Project Name: Coors & Western Trail Tract 3A

May 18, 2021

**RE: RESPONSE TO STORMWATER QUALITY COMMENTS
ATIVO ALBUQUERQUE LLC – 4500 QUAKER HEIGHTS
EROSION AND SEDIMENT CONTROL PLAN**

ENGINEER'S SEAL	EROSION CONTROL PLAN	DRAWN BY RG
 5/17/2021		DATE 05/17/2021
		DRAWING 2019064-SWPPP
RONALD R. BOHANNAN P.E. #7868	 <i>TERRA WEST, LLC</i> 5571 MIDWAY PARK PL NE ALBUQUERQUE, NEW MEXICO 87109 (505) 858-3100 www.tierrawestllc.com	SHEET # SW-1 JOB # 2019064

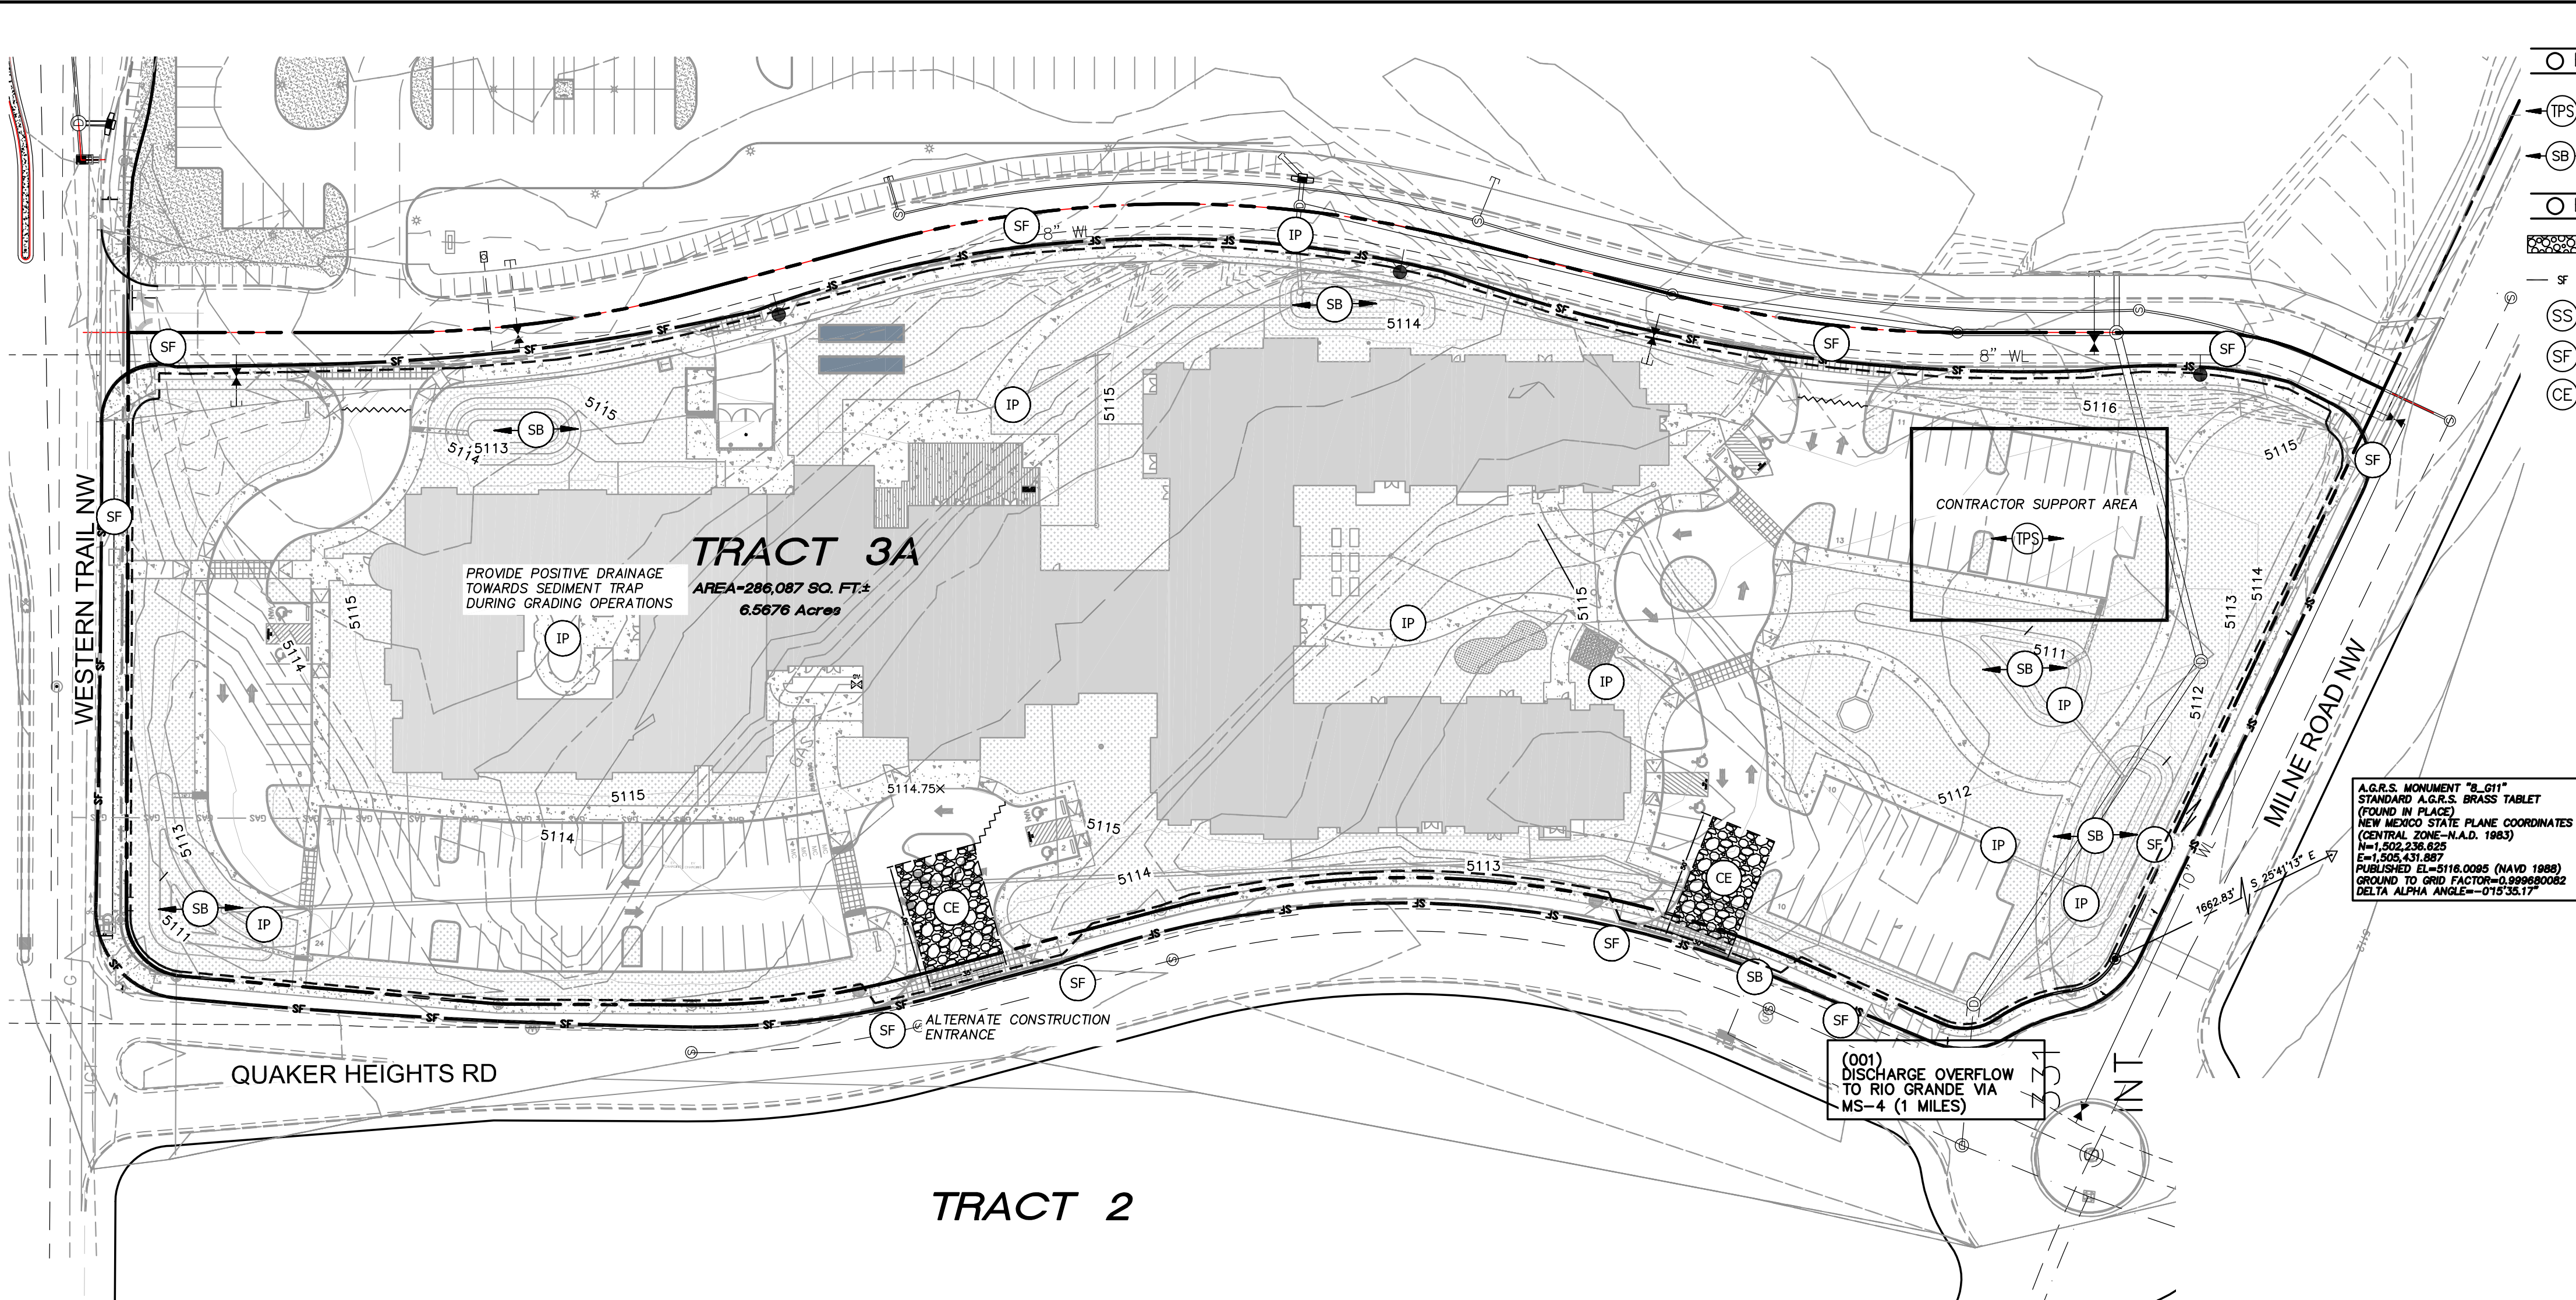
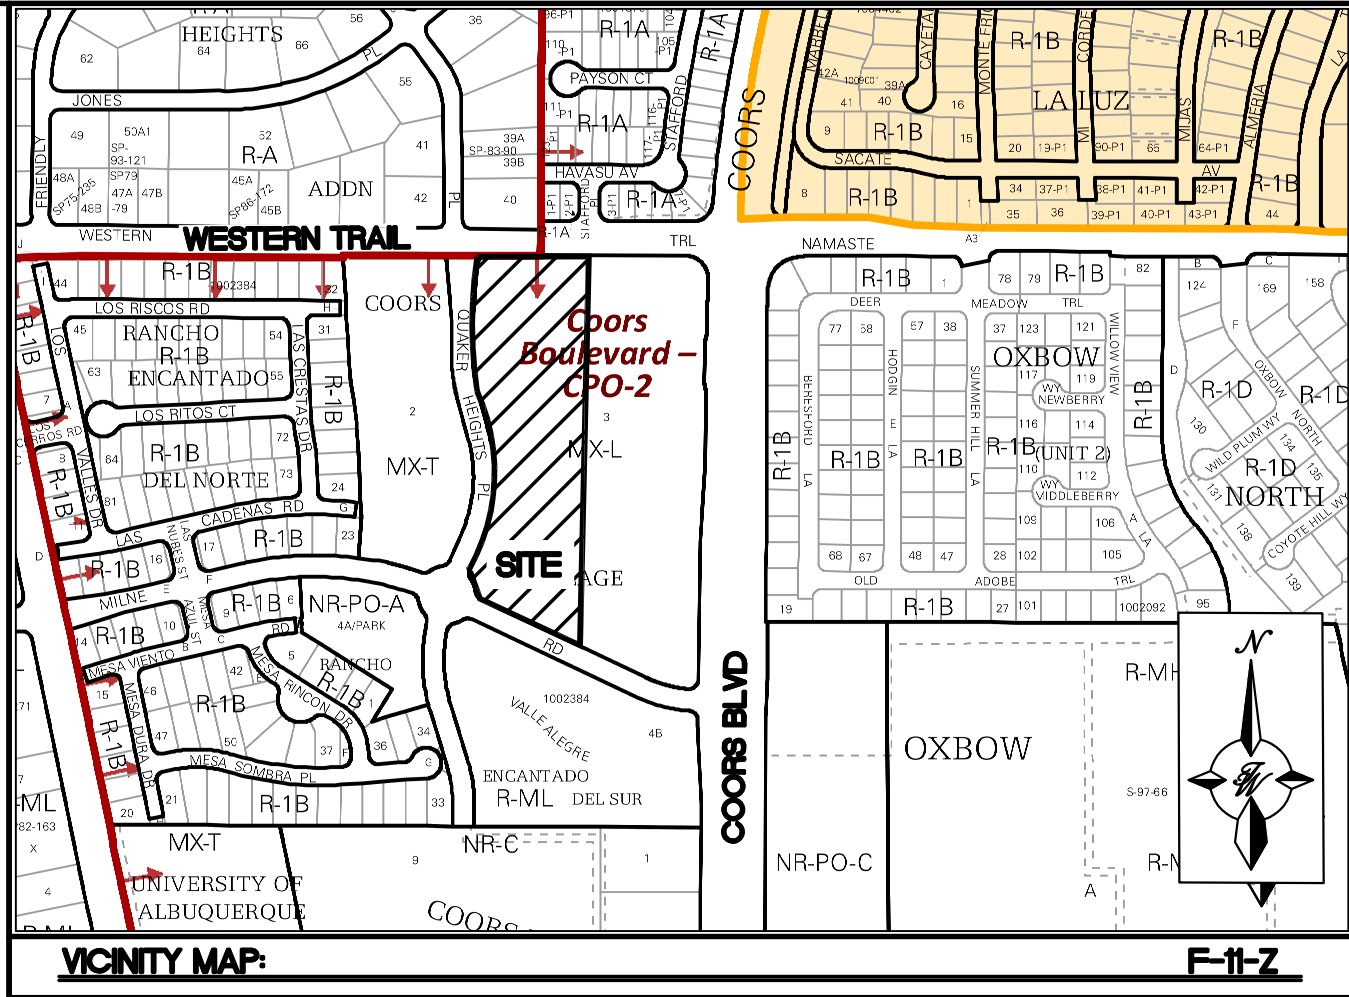
1. The "limits of disturbance" symbol in the legend is not shown anywhere on the plan. Clearly indicate the limits of disturbance. (CGP7.2.4.b.i)
Response: The limits of disturbance are now shown on the plan with line work matching that of the legend.

Response: The site plan is being included in this ESC Plan resubmittal package.
3. Describe undisturbed and pre-construction ground cover (CGP7.2.4.e)
Response: A "Undisturbed and Pre-Construction Ground Cover" note has been added to the plan for describing existing ground cover.

4. List operators on the plan, including name, phone #, and e-mail address. Include the developer/property owner's representative authorized to make changes to contract documents, plans, and specifications per CGP 7.2.1. If there are multiple operators describe the area of control for each. State whether the operators will share a SWPPP or if they will each have separate SWPPPs

Response: The operators (the owner and contractor) are now listed on the plan with contact information.
5. Identify stormwater team members responsible for sediment removal, BMP maintenance, and inspections on the plan, including name, phone #, and e-mail address (CGP 7.2.2). Provide the stormwater team for each operator

Response: A stormwater team members list has been added to the plan with contact information.
6. Describe the nature and extent of construction activities for each operator (CGP7.2.2.), including a) nature of construction activities, b) size of the property, c) size of disturbed area, d) description of construction support activities, and e) size of maximum disturbed area.

8. Soil information – add a table with name type, particle sizes, and Erodibility factor (CGP 2.1.1).

10. City Standard ESC Notes attached.

Response: This information has been added to the plan.

Response: A soil information sheet has been added to the plan for providing this information.

Response: These notes have been added to the plan.
